**Submission from:**

Dolores Bragg, 7 Cowells Lane, Ermington NSW 2115  
Parent of 3 students & Acting President, Marsden High School P&C Association

**Application Name:** Meadowbank Education and Employment Precinct Schools Project –  
Modification 4 – SSD-9343-Mod-4

Figure 9.10: Proposed Mitigation (phasing) at Victoria Road and Hermitage Road intersection

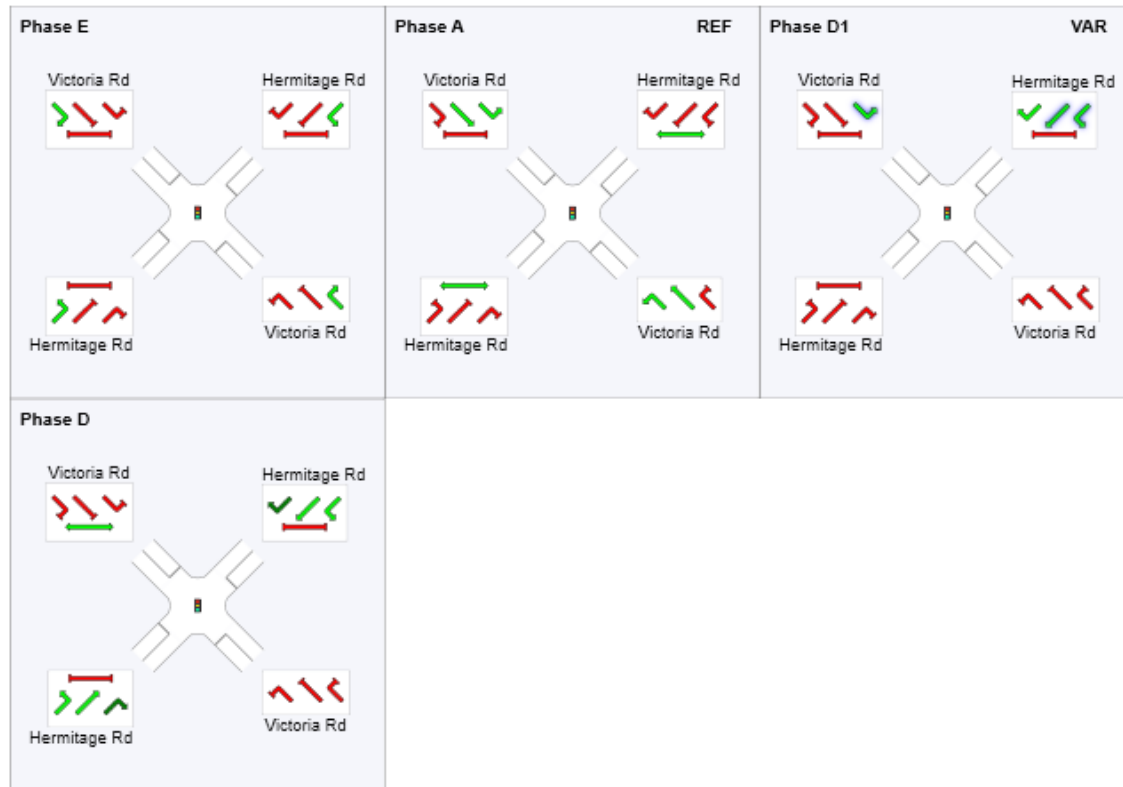
Another issue is the **Traffic light timing** at the intersection of Victoria Road to Hermitage Road: This timing of the lights is way too short for both motor vehicles and student pedestrians to cross Victoria Road.

Nonetheless, it is even worse for vehicles travelling along Hermitage Road from the north of Victoria Road and turning right (westward) into Victoria Road. Many of these vehicles do a work around which involves going straight through the intersection, then making a U-Turn in the southern part of Hermitage Road, and then turning left into Victoria Road.

Figure 26 | Location of Department's recommended pedestrian infrastructure upgrades (Base source: Nearmap)

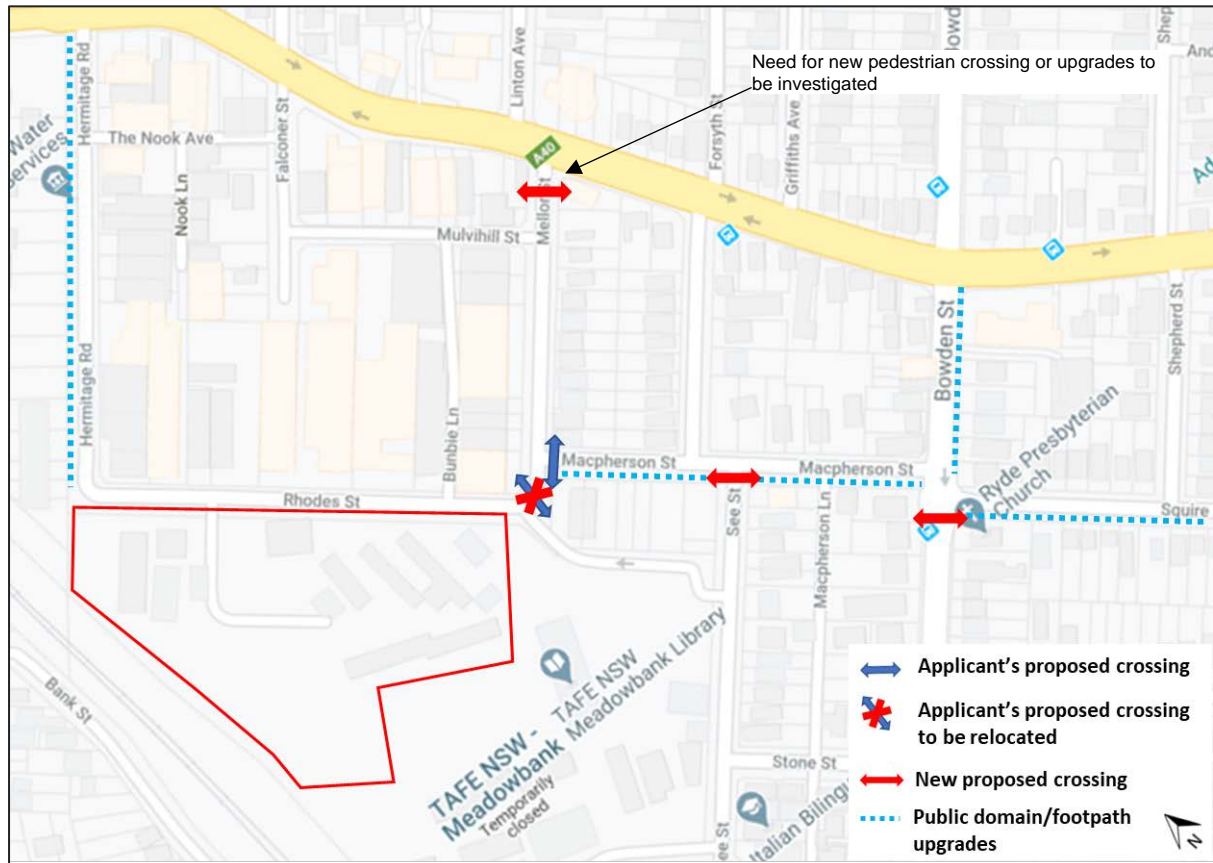
- **Deletion of the requirement to provide a 2.5m wide shared user path along the western side of Hermitage Road – REJECT** - The current footpath on Hermitage Road runs out after about 100m and turns into a grassed section, not level to walk on. It was part of the approvals to install a footpath along this section of road which leads to the school. The project team believe it will be too costly to install due to services that run under that section of ground and have put in a modification to plan seeking to exclude this footpath from being installed.

- Changes to footpath upgrade requirements along Bowden Street and Squire Street – **REJECT** – these footpaths need to safely accommodate the number of children and families who will walk these streets to and from school.

- **See Street: - REJECT** - The Project Team has said that Council have instructed them to not install the pedestrian crossing that was planned for this intersection. **The Council have denied this and have written to confirm that they do want this pedestrian crossing included in the scope of the build as per the original requirements.** This omission is ludicrous when it is the direct crossing that families will need to take to enter the school when walking from down Bowden Street and either MacPherson Street or up See Street from Angus Street.
- **Rhodes Street and Macpherson Street – REJECT** - removal of pedestrian crossing in Kiss and Ride area.
